File No: NTH17/00098  
Your Ref: SSD 8658

**Oxley Highway [HW11] and Kamilaroi Highway [HW29]. Gunnedah Solar Farm.  
Development Application – 765 Orange Grove Road, Gunnedah.**

Roads and Maritime has reviewed the Traffic Impact Assessment (TIA) and provides the following comments to assist the consent authority in making a determination;

TYPICAL CROSS-SECTION 5.5m/6.5m WIDE SEALED ACCESS ROAD FROM ORANGE GROVE ROAD TO SUBSTATION DETAIL (FILL)

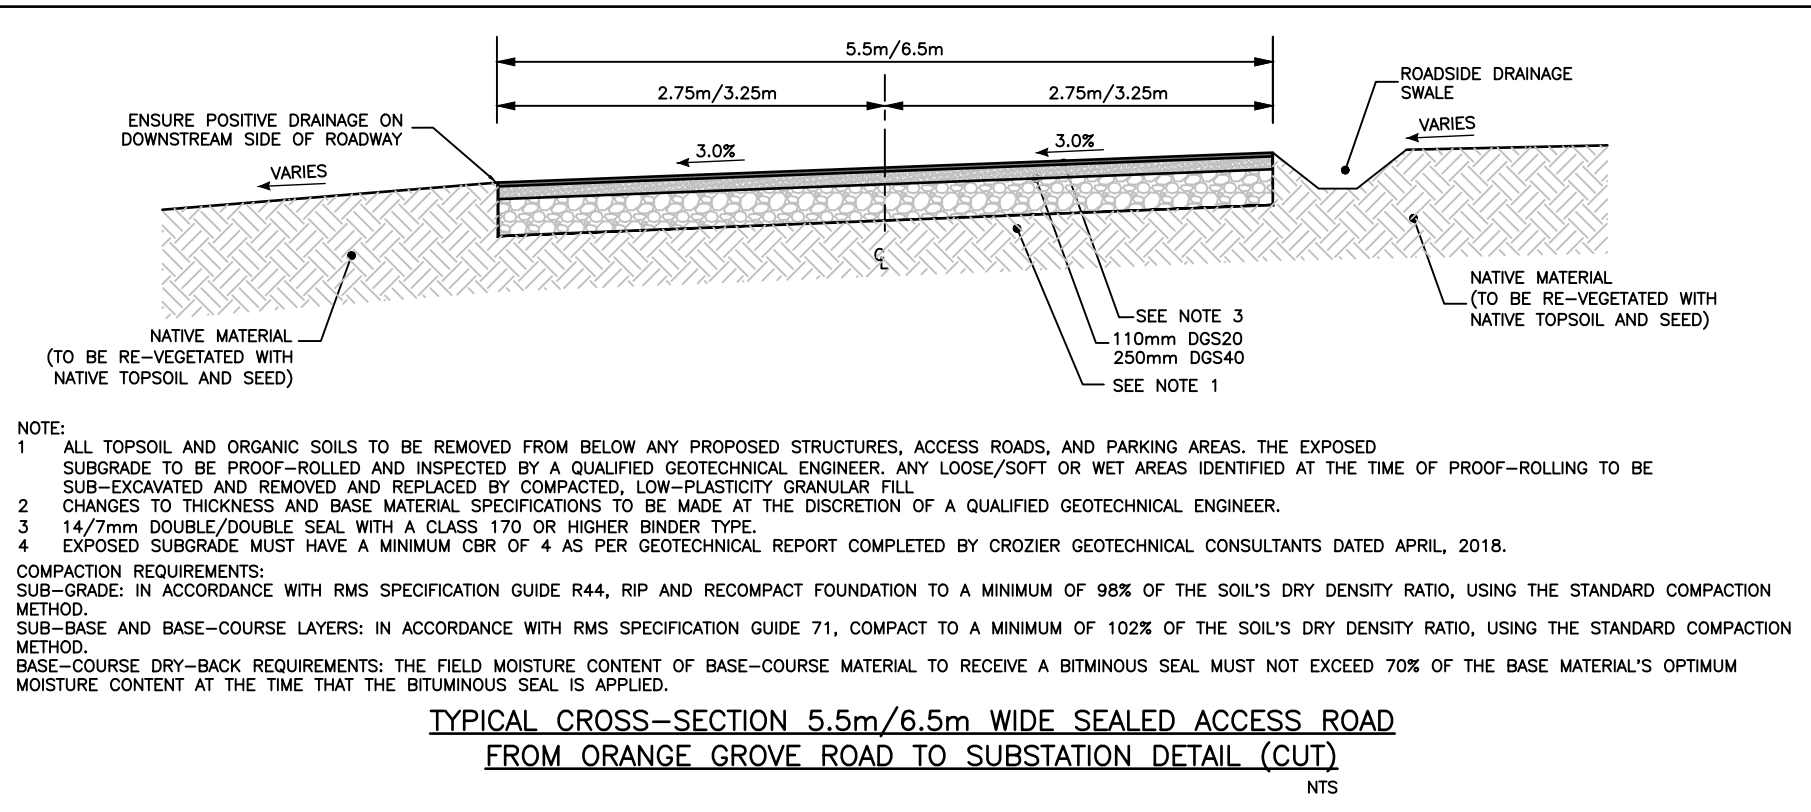
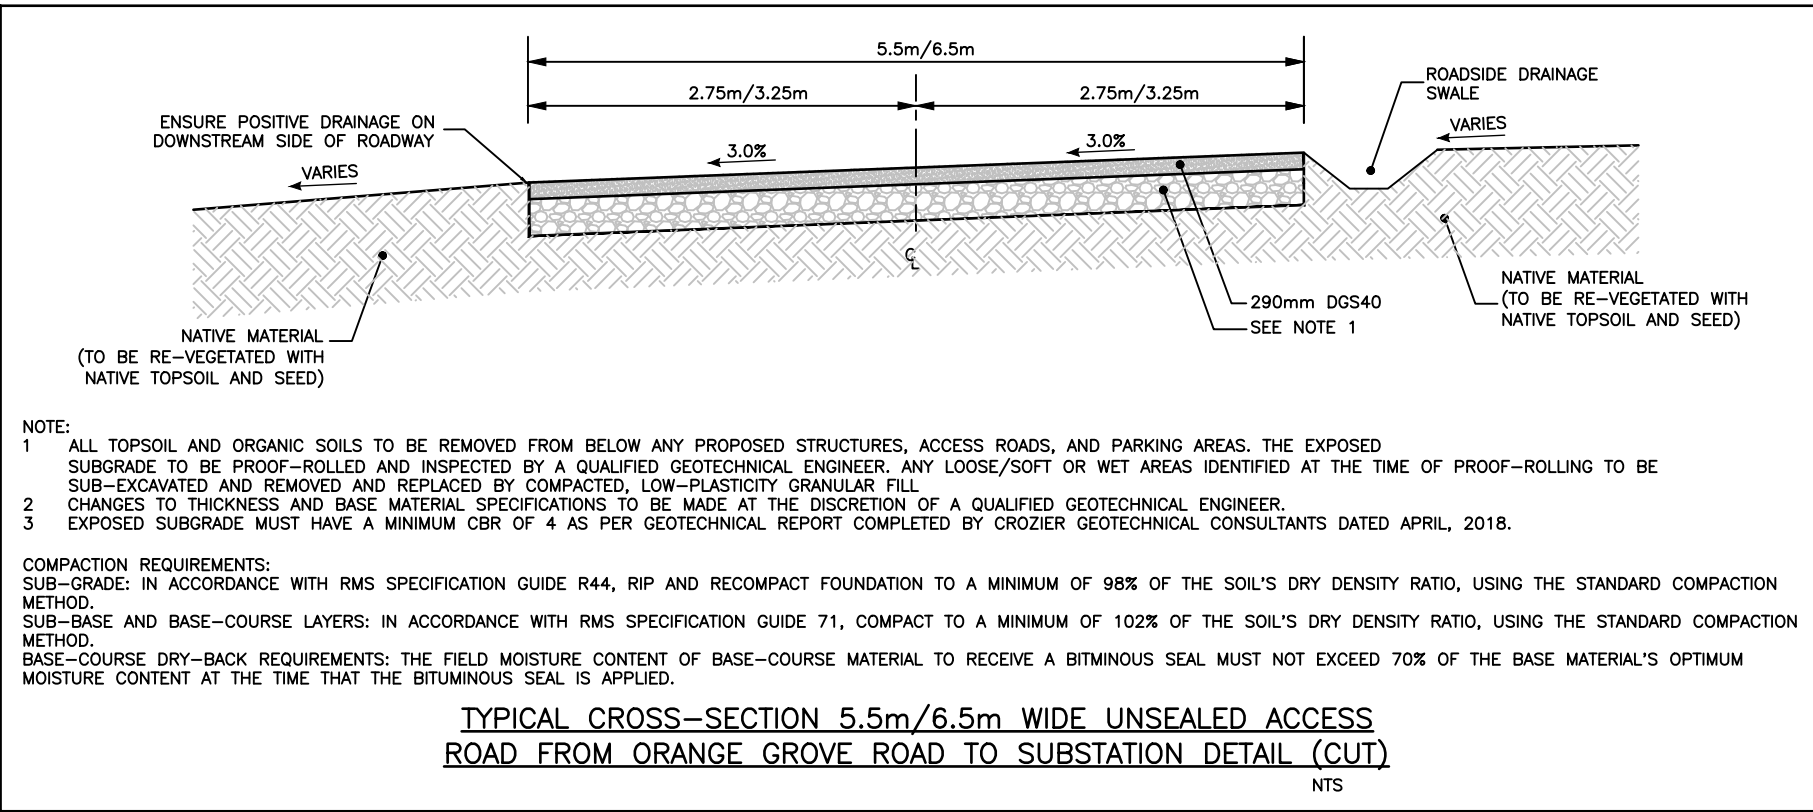
2. Should over mass, over dimension (OMOD) vehicles be required at any stage of the development then a Permit from Roads and Maritime would be required.
3. Access to the development is proposed from a Local road. The access should be designed and constructed in accordance with Austroads Guidelines and Australian Standards, to the satisfaction of Gunnedah Shire Council. It is recommended that swept path analysis be undertaken to ensure the largest design vehicle can safely enter and exit the site in a forward manner.
4. It is the land owner's responsibility to maintain any access driveways to the development to improve safety and efficiency of access and to minimise the generation of dust and/or tracking of material onto the public road.
